From: [REDACTED]
Sent: 25 April 2022 13:08
To: Planning
Subject: Planning Application No; 3/2022/0105 Bck St Pauls Street

Response to RETROSPECTIVE planning application for amended turning circle and refuse bin collection point for Planning Application No:3/2022/0105

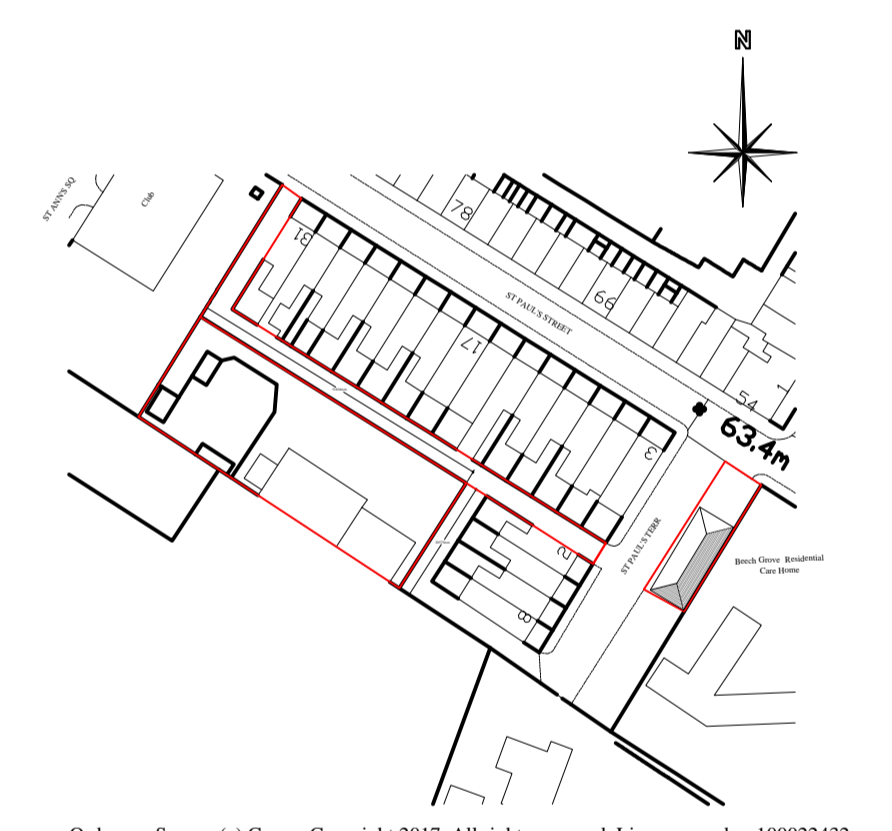
The reduction of the turning area is not practical as quite simply vehicles such as emergency service and delivery vehicles will not be able to turn round safely as there is not enough room. This is a major concern in case of things like fire etc,

Approx 70% of this development is now encased in an unplanned 1.8 metre high wooden fence which contravenes the original 1.2 metre stone wall to the front of the properties and a maximum 1 metre wall at the rear. No new planning permission has gone in for this and [REDACTED] blend in with the existing environment. The height of this fence makes it a danger to pedestrians and motorists alike as it blocks the line of sight for people and children exiting the Club and play area.

- [REDACTED] Now the turning circle amounts to little more than a small lay-by which will not provide adequate turning for large service or emergency vehicles.

- This back street is the new houses **ONLY** access for their residents and any deliveries. Most delivery, service and large vehicles will need to reverse to exit via St Paul's terrace unless the turning circle is restored.

- All the backgates no 5-31 lead directly onto the back street with **NO FOOTPATH** provision. Consequently all traffic up or down the **narrow** back is a danger to all residents stepping out, and a danger to all pedestrians, dog walkers, children and cyclists who frequently use the back to access Roefield Playing field.

In the light of these observations I hope that you insist that the original plan for the turning circle is followed to the letter and take the safety of all to be the determining factor
Yours Faithfully
